Project Name: Coors & Western Trail Tract 3A

May 18, 2021

**RE: RESPONSE TO STORMWATER QUALITY COMMENTS
ATIVO ALBUQUERQUE LLC – 4500 QUAKER HEIGHTS
EROSION AND SEDIMENT CONTROL PLAN**

ENGINEER'S SEAL	DRAWN BY RG
RONALD R. BOHANNAN NEW MEXICO 7868 PROFESSIONAL ENGINEER	DATE 05/17/2021
TIERRA WEST, LLC 5571 MIDWAY PARK PL NE ALBUQUERQUE, NEW MEXICO 87109 (505) 858-3100 www.tierrawestllc.com	DRAWING 2019064-SWPPP
RONALD R. BOHANNAN P.E. #7868	SHEET # SW-1
	JOB # 2019064

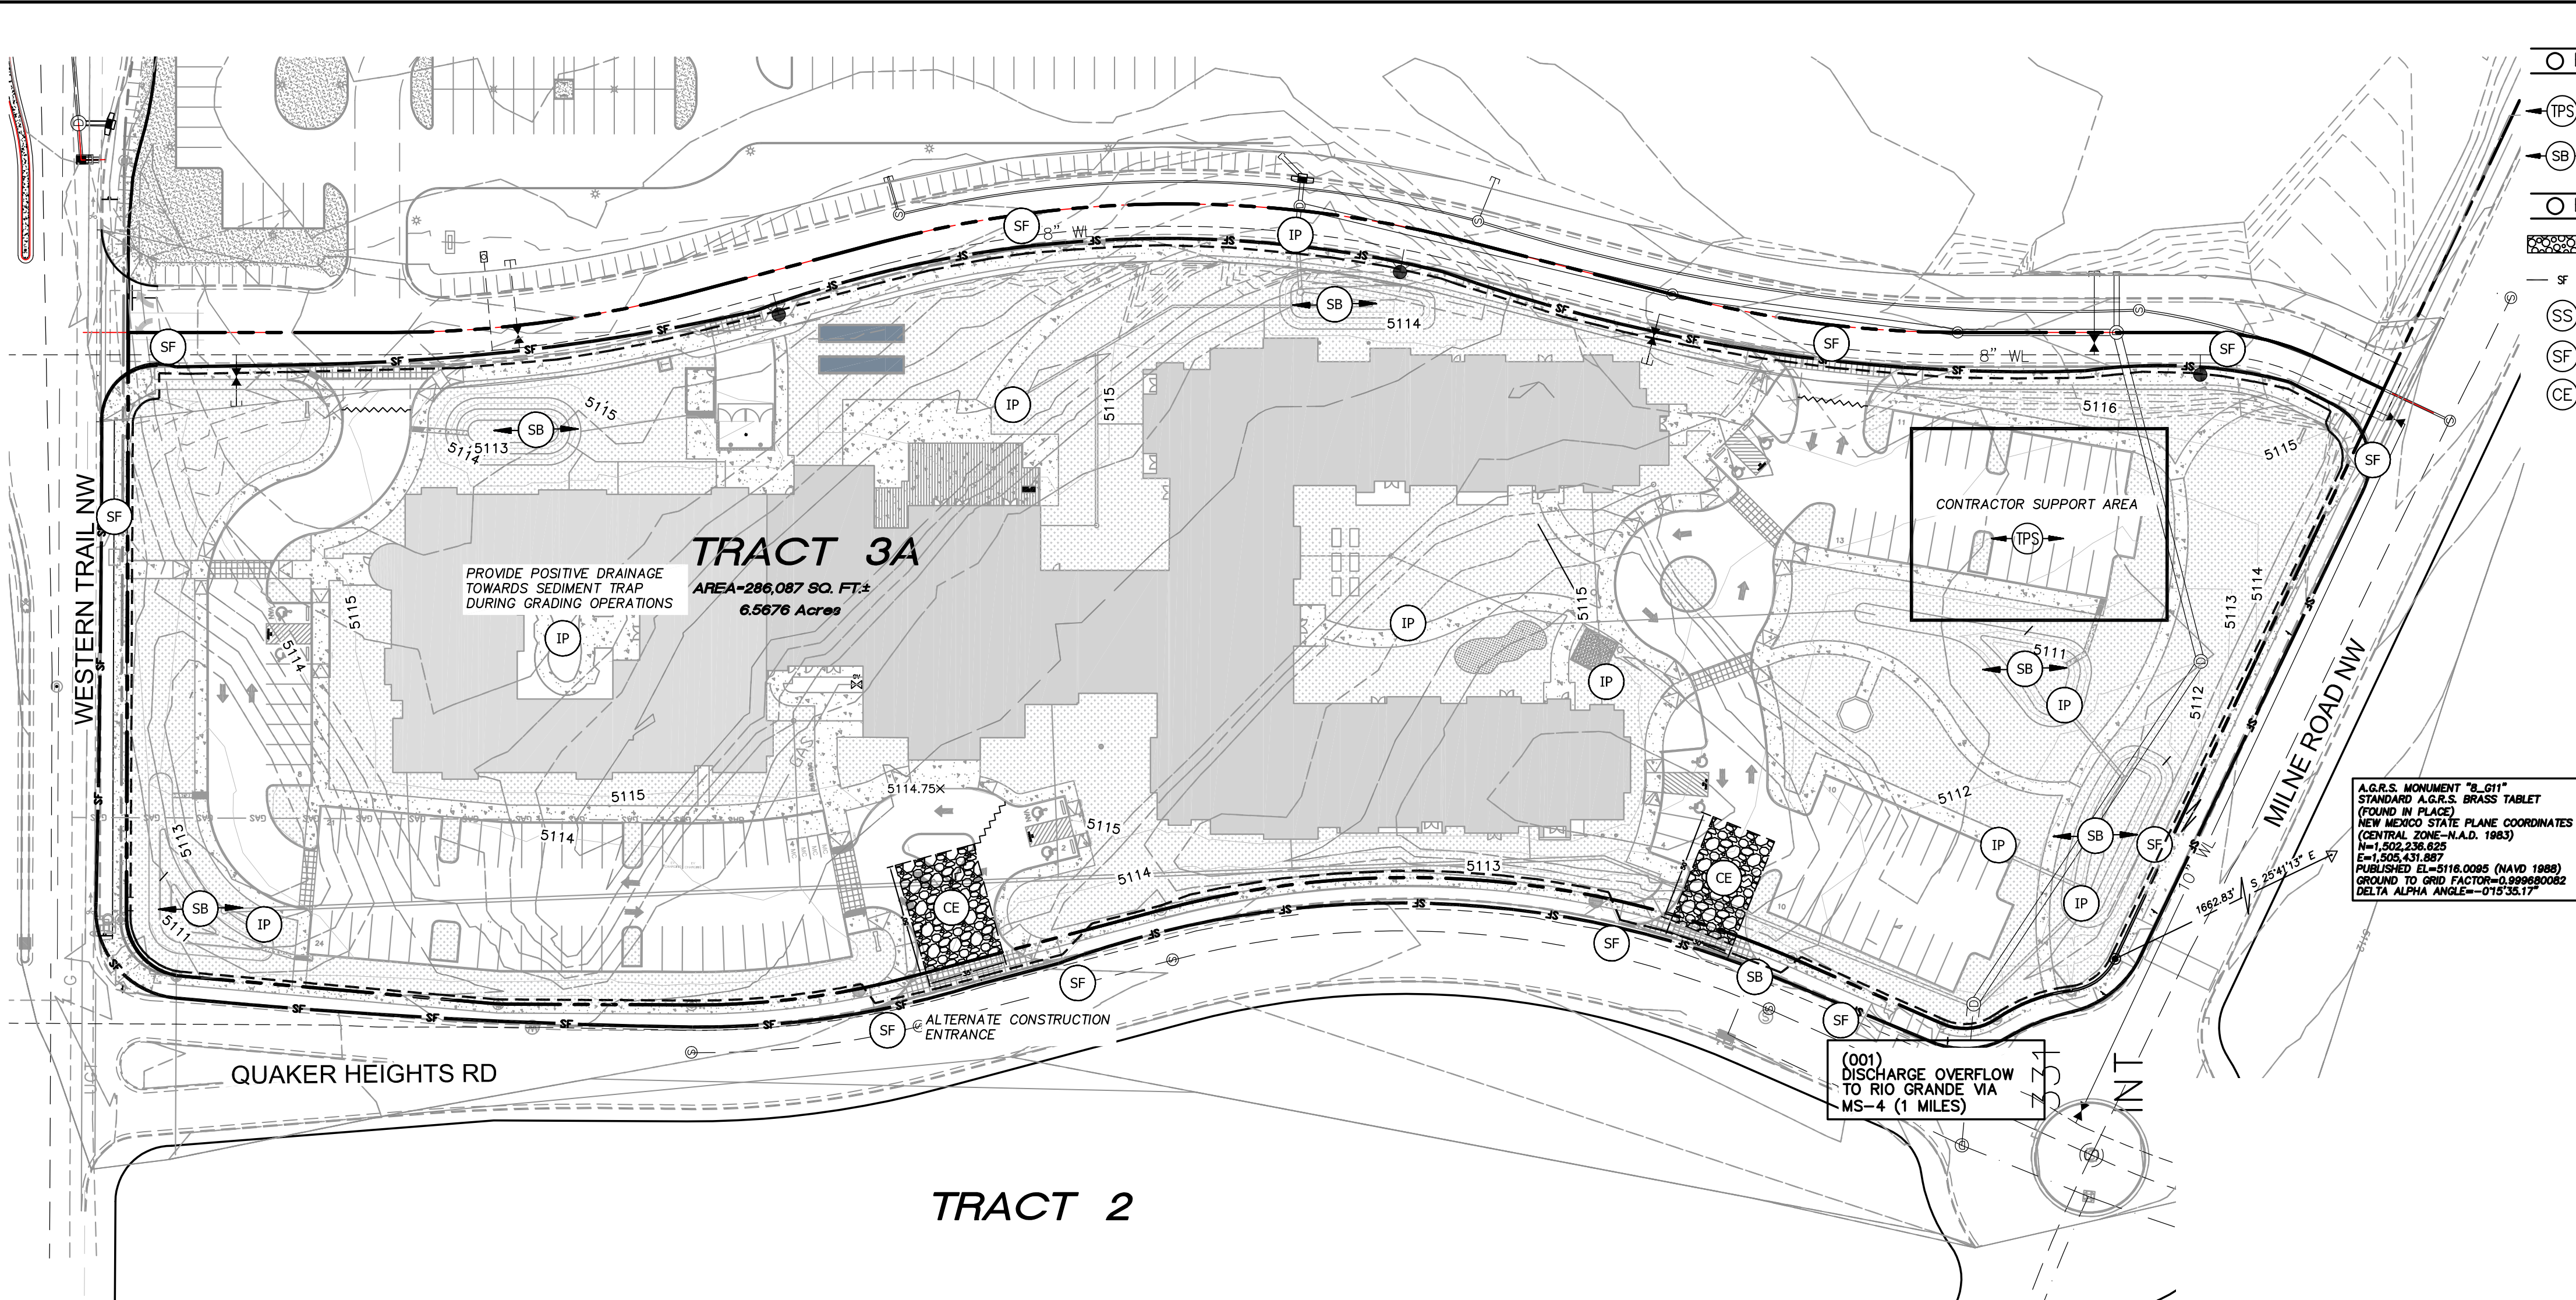
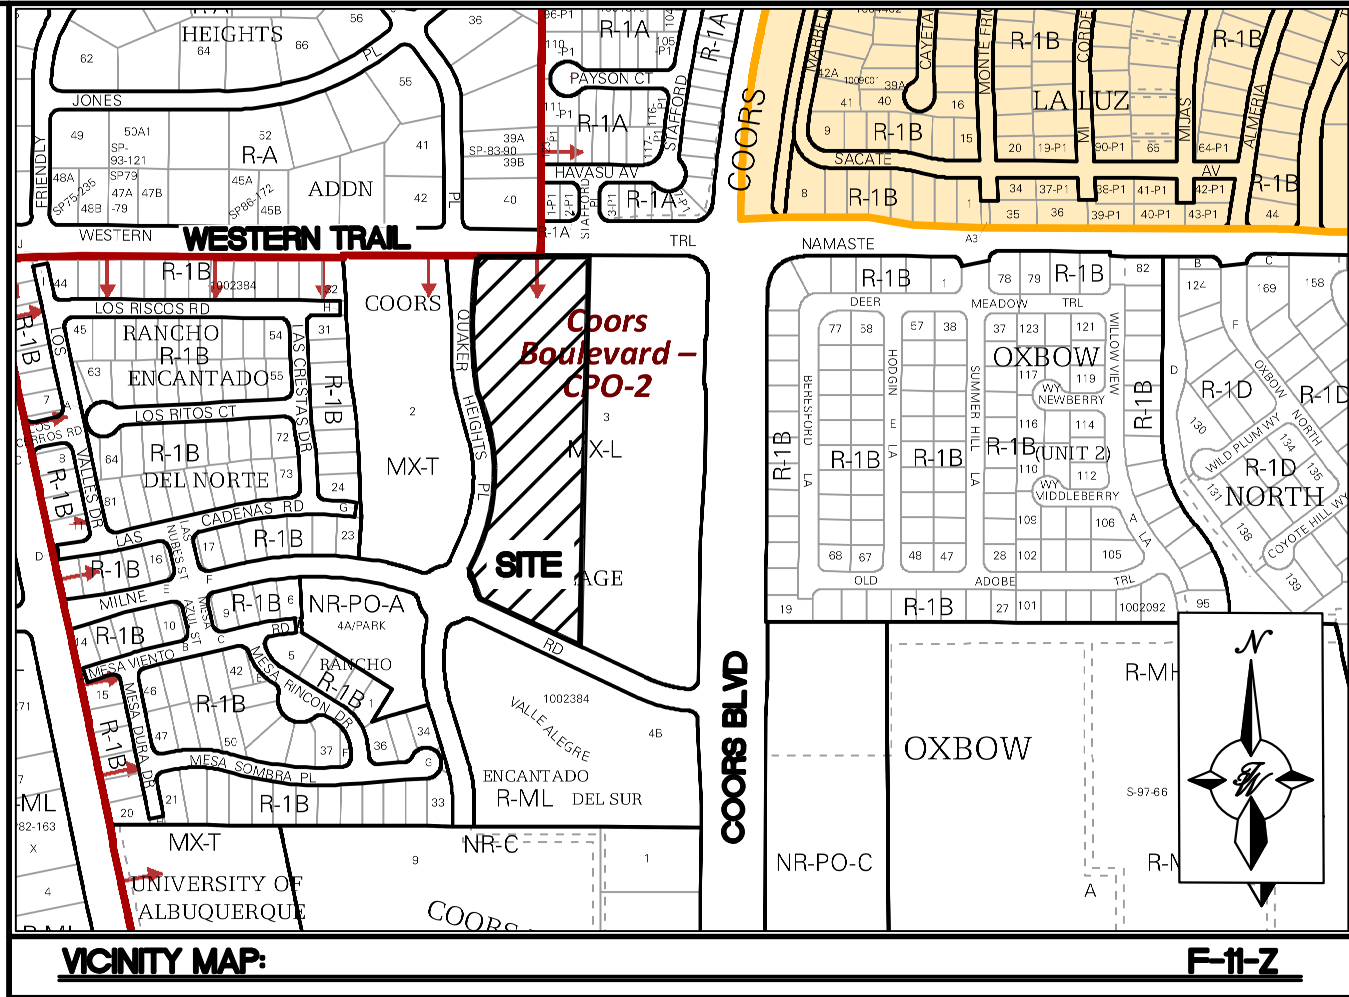
1. The "limits of disturbance" symbol in the legend is not shown anywhere on the plan. Clearly indicate the limits of disturbance. (CGP7.2.4.b.i)
Response: The limits of disturbance are now shown on the plan with line work matching that of the legend.

2. The locations of structures and other impervious surfaces. (CGP7.2.4.b.v). The Site Plan can be used to satisfy this requirement and should be included in the SWPPP and the ESC Plan submittal.

4. List operators on the plan, including name, phone #, and e-mail address. Include the developer/property owner's representative authorized to make changes to contract documents, plans, and specifications per CGP 7.2.1. If there are multiple operators describe the area of control for each. State whether the operators will share a SWPPP or if they will each have separate SWPPPs

Response: The operators (the owner and contractor) are now listed on the plan with contact information.
5. Identify stormwater team members responsible for sediment removal, BMP maintenance, and inspections on the plan, including name, phone #, and e-mail address (CGP 7.2.2). Provide the stormwater team for each operator

Response: A stormwater team members list has been added to the plan with contact information.
6. Describe the nature and extent of construction activities for each operator (CGP7.2.2.), including a) nature of construction activities, b) size of the property, c) size of disturbed area, d) description of construction support activities, and e) size of maximum disturbed area.

8. Soil information – add a table with name type, particle sizes, and Erodibility factor (CGP 2.1.1).

9. Update the engineer's stamp date each time the plan is changed.

10. City Standard ESC Notes attached.

Response: This information has been added to the plan.

Response: A soil information sheet has been added to the plan for providing this information.

Response: The engineer's stamp date has been updated for this most recent resubmittal.

Response: These notes have been added to the plan.
